STERLING RANCH FILING NO.2

FINAL GRADING & EROSION
CONTROL PLAN

SHEET 6 OF 13

SHEET 6 OF 13
JOB NO. 25188.01

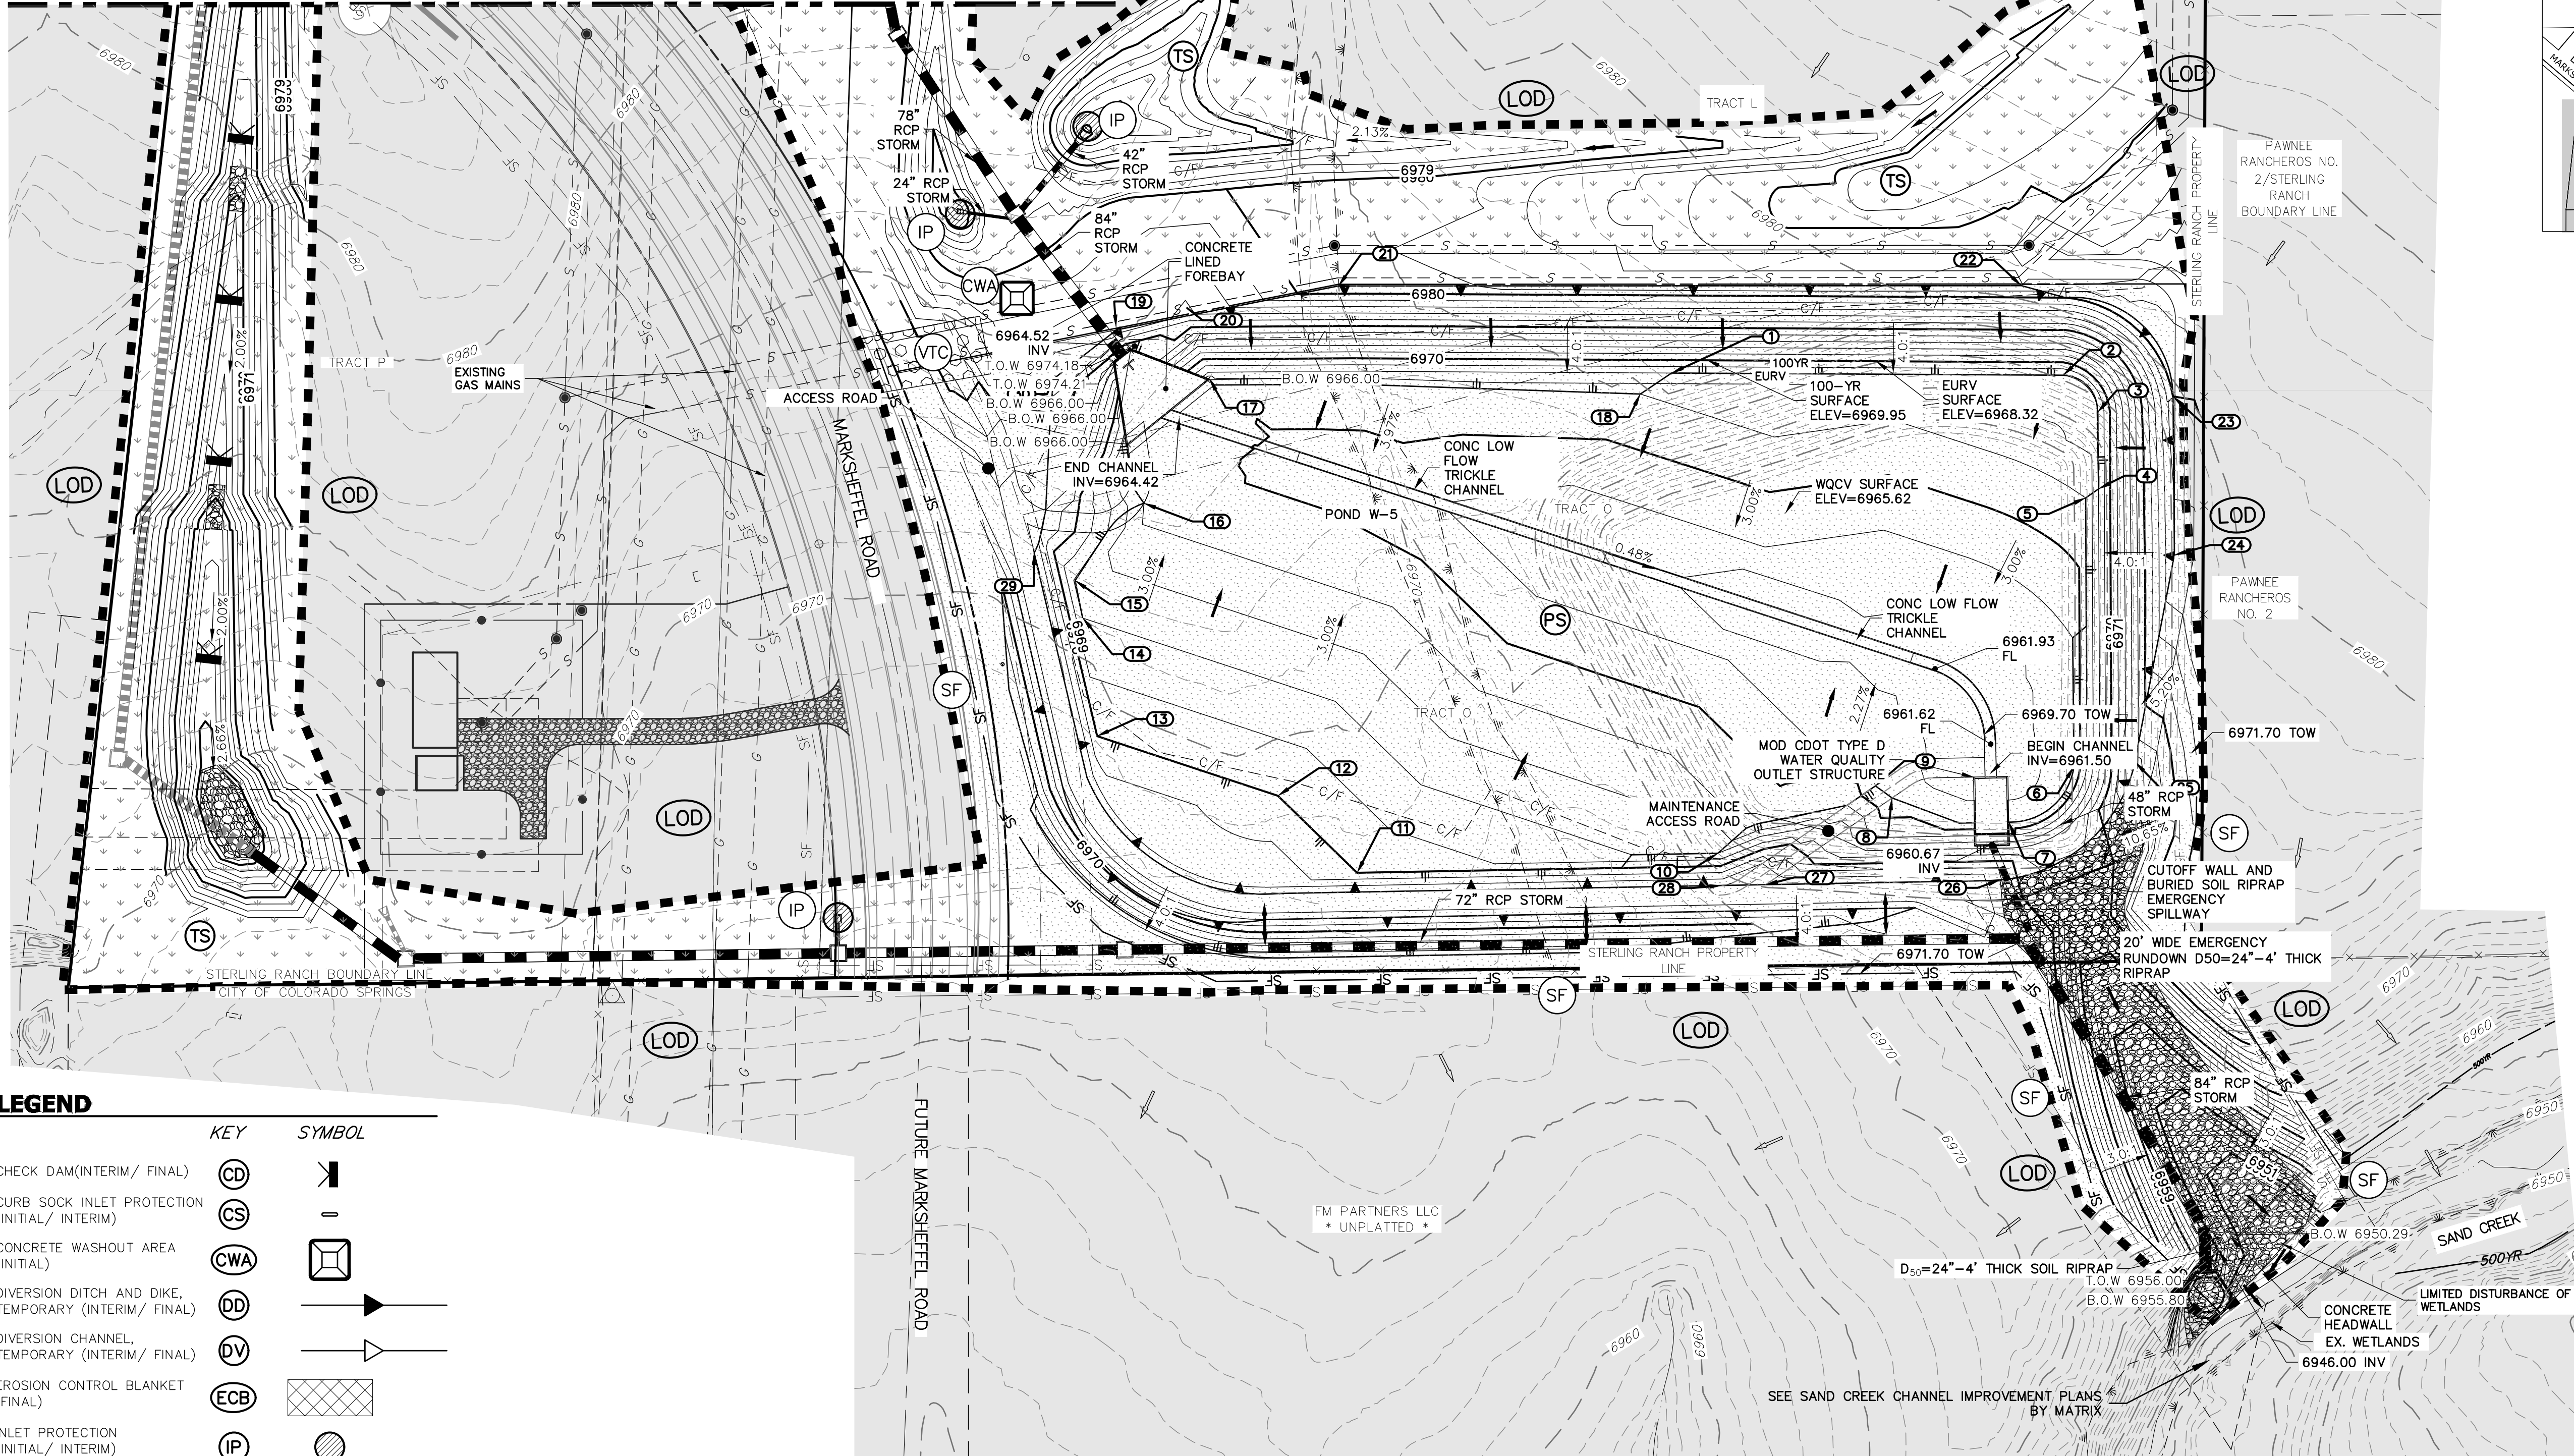
This grading will require a construction easement

JR Response: Grading and drainage revised to remove grading on school site.
